Letter of Intent_V1.pdf Markup Summary

This letter is a request to update the current site plan for American Dog Pros, 12900 Murphy Rd, Elbert, Co. There is an existing major dog kennel business at this property owned by IC4/Chris Dunlap 719 287-1449, chrisdunlap.03@gmail.com.

Footprint of all existing and proposed buildings and the setback distances from each existing and proposed structure to the property lines. No sidewalks.

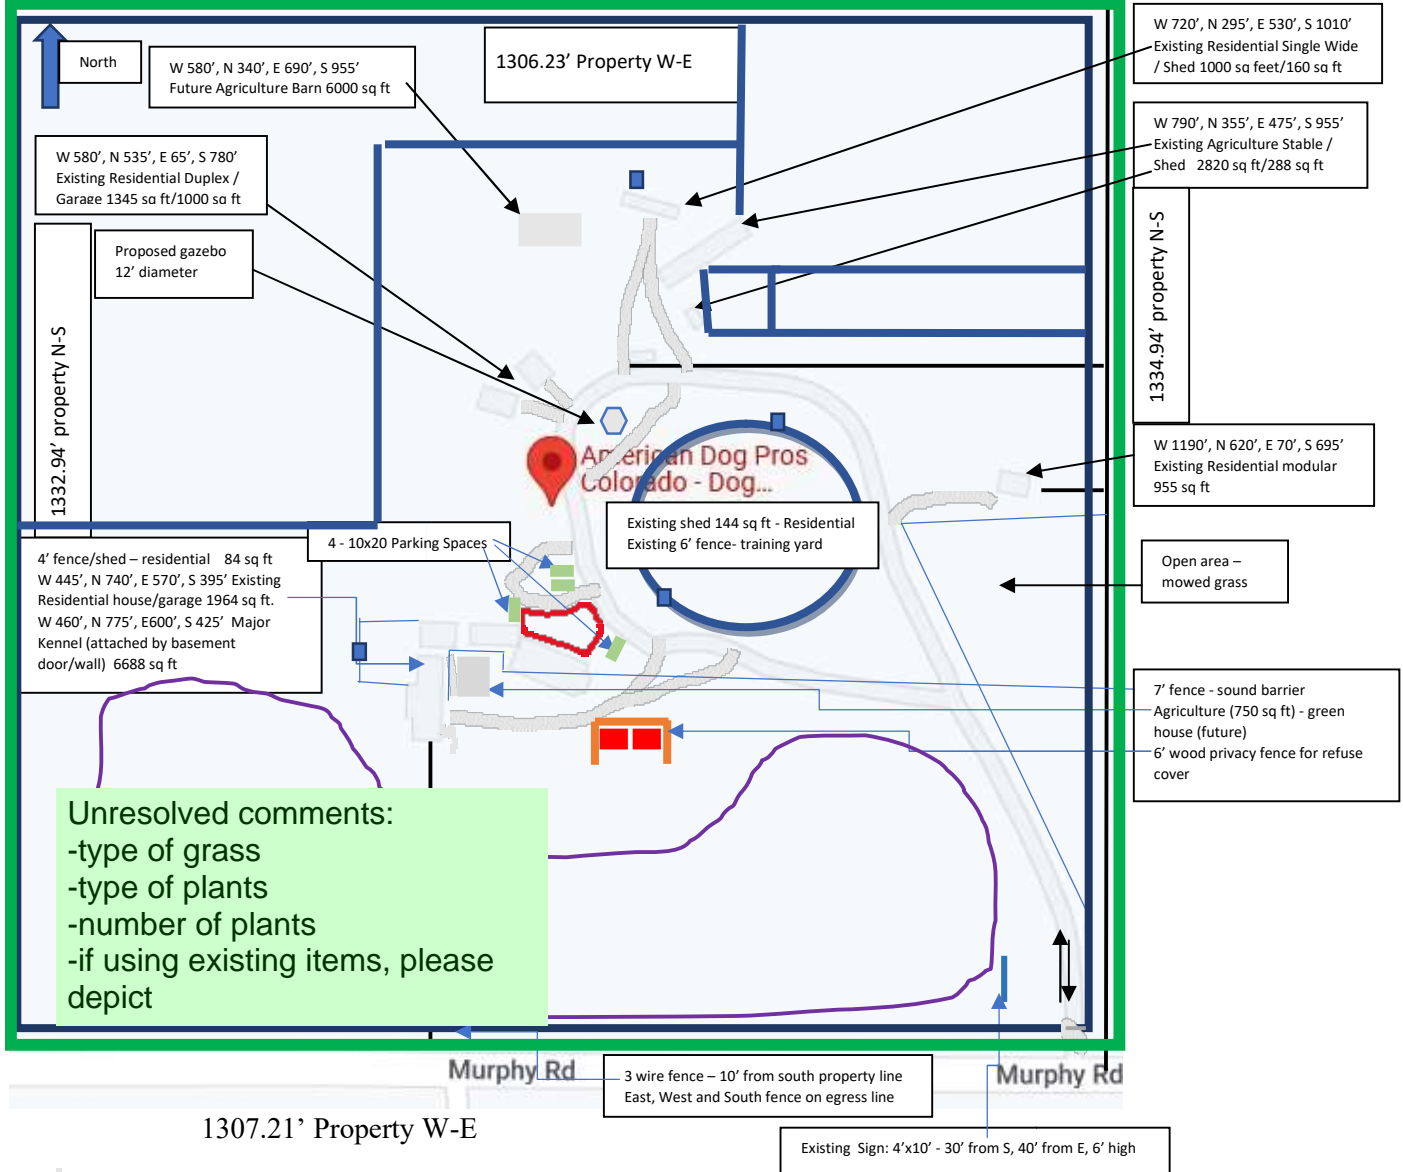
See comment above regarding use of the proposed barn and greenhouse. This may impact parking space calculations.
